**Response to Planning application from Hertfordshire County Council (T and CP GDP Order 2015)**

District ref: 6/2022/2797/FULL  
HCC ref: WH/15160/2022  
HCC received: 23 December 2022  
Area manager: Manjinder Sehmi  
Case officer: Sarah Forty

Ymca 90 Peartree Lane, Welwyn Garden City AL7 3UL

Erection of electricity substation

047-WPA-ZZ-00-DR-A 7008

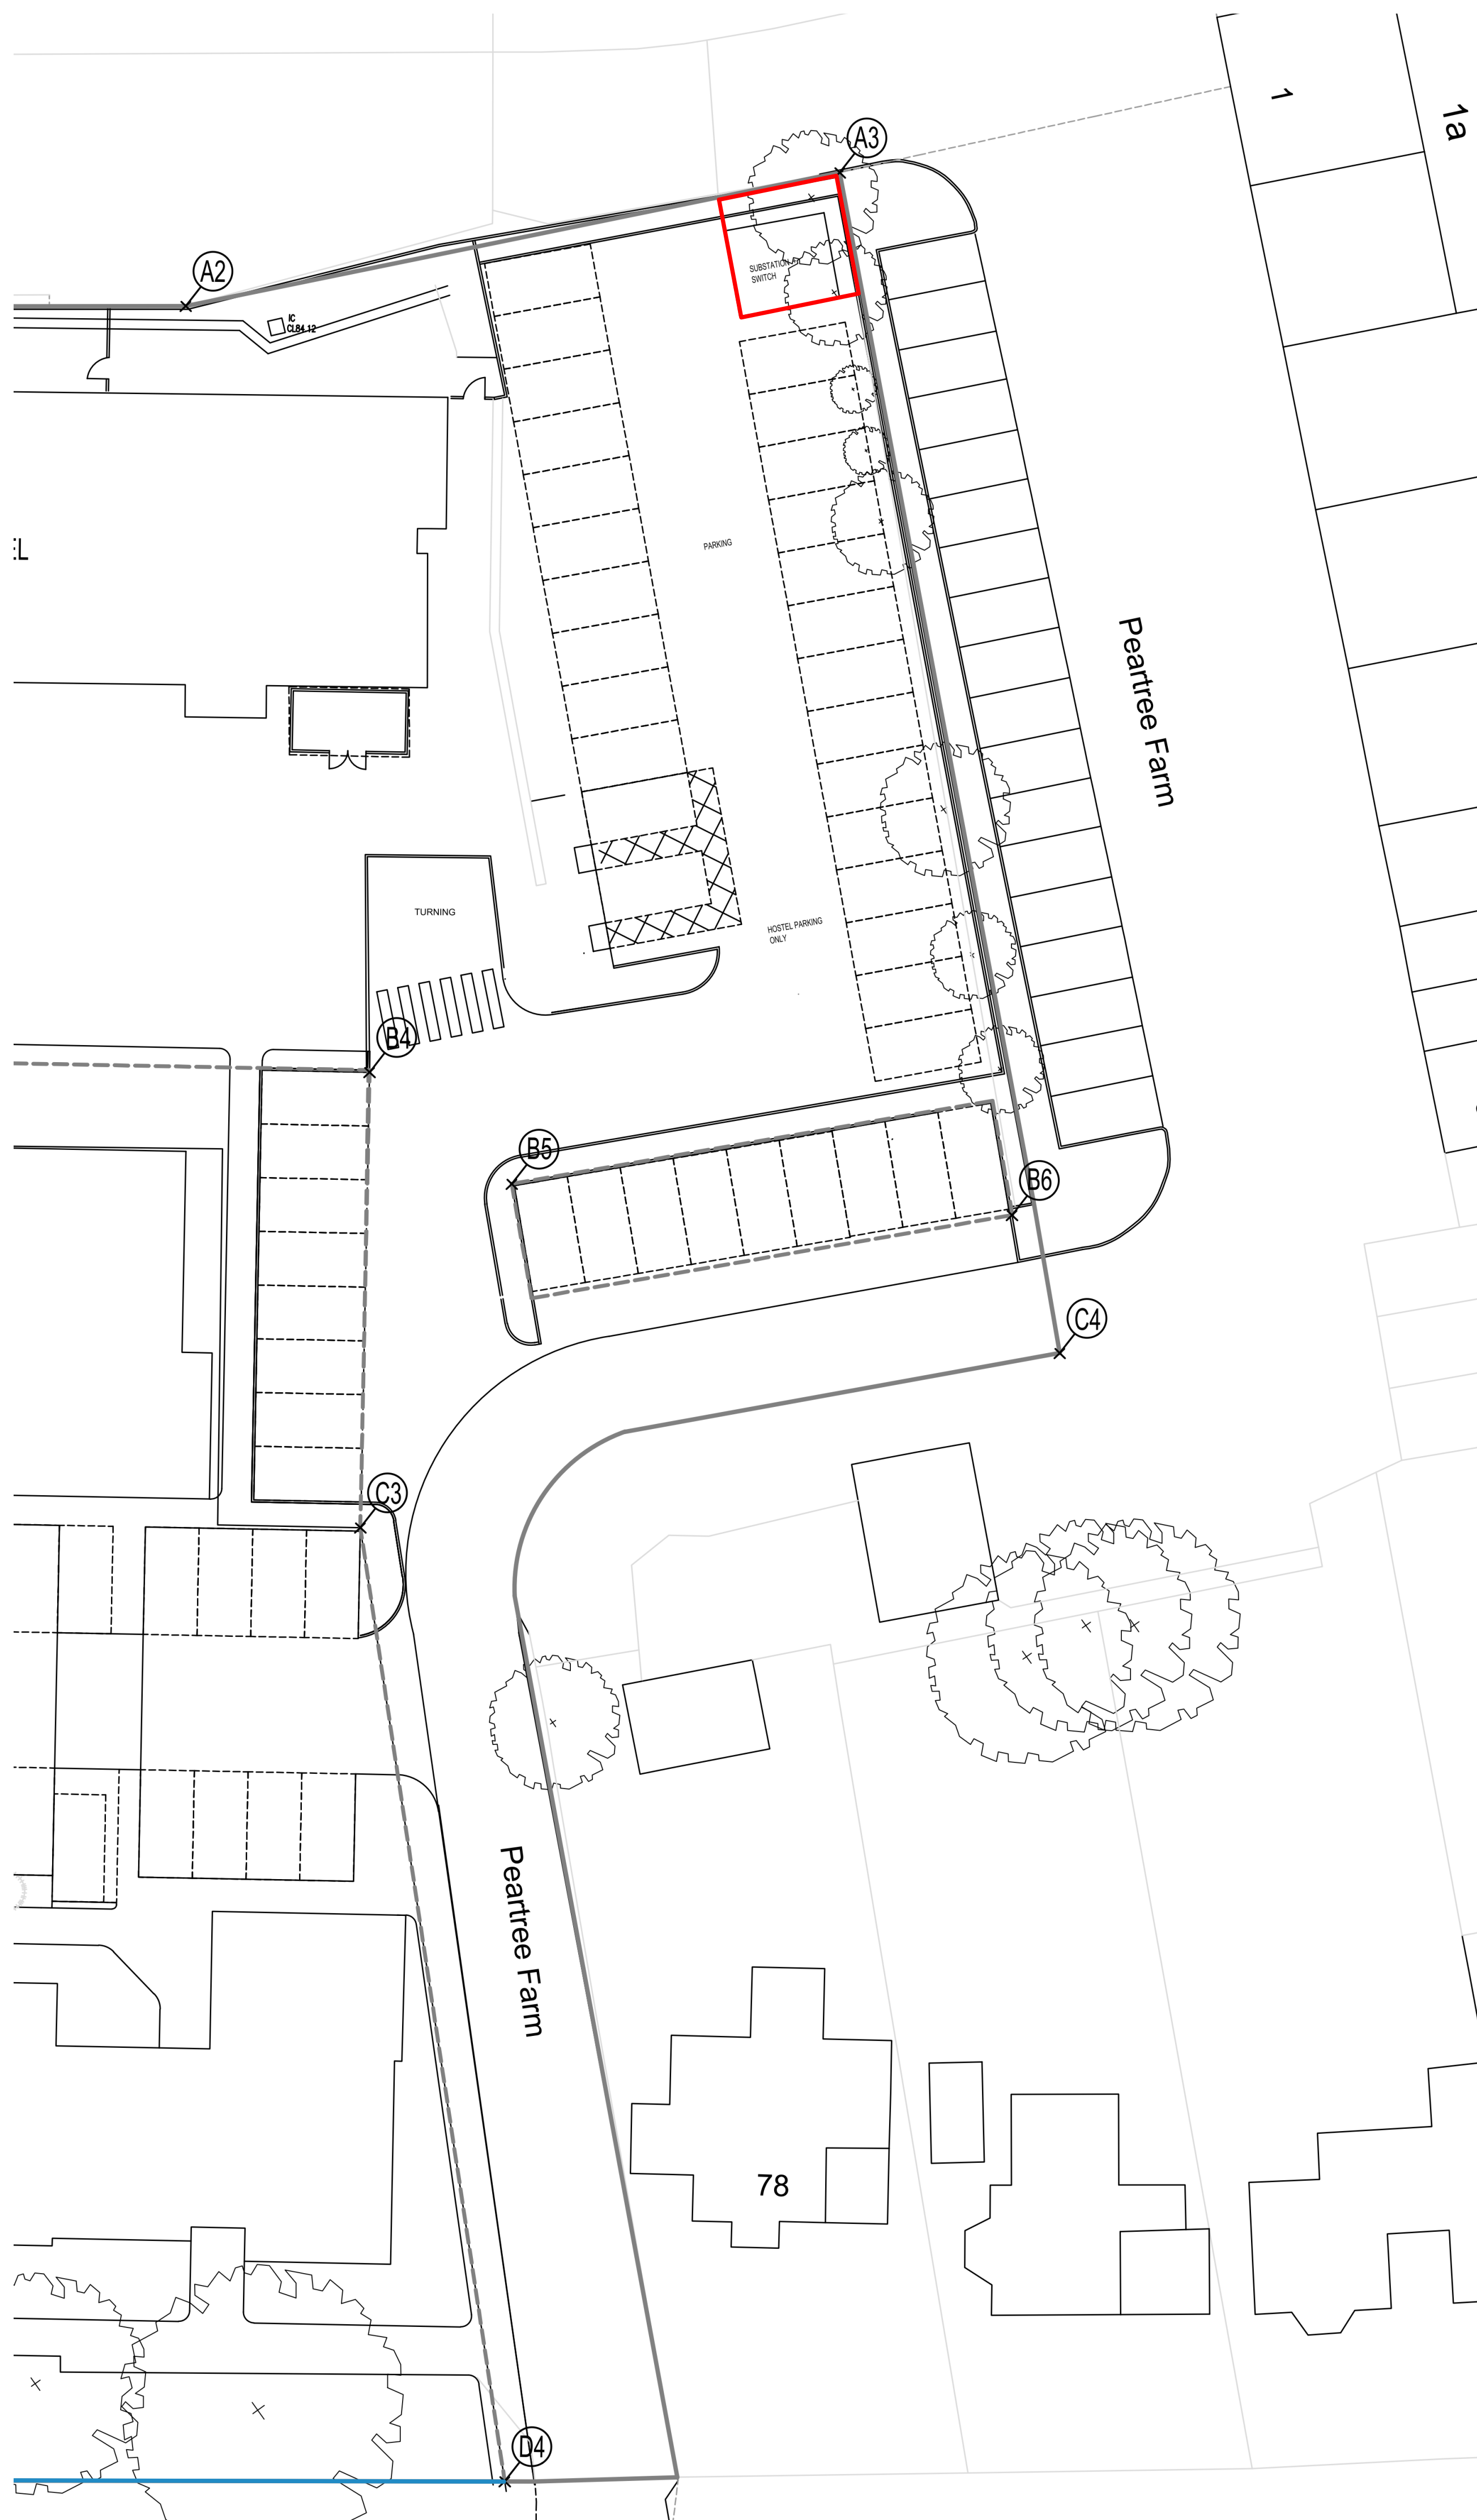
Ultimately the LPA will have to be satisfied with the parking provision, but HCC would like to comment that the proposed substation is located within the carpark of the site and drawing number 047-WPA-ZZ-00-DR-A-7008 indicates that the substation will result in a loss of two parking spaces at the site. It is noted that there are other parking areas within the site, but that there are double yellow lines on the surrounding carriageways meaning on street parking is not available surrounding the site.
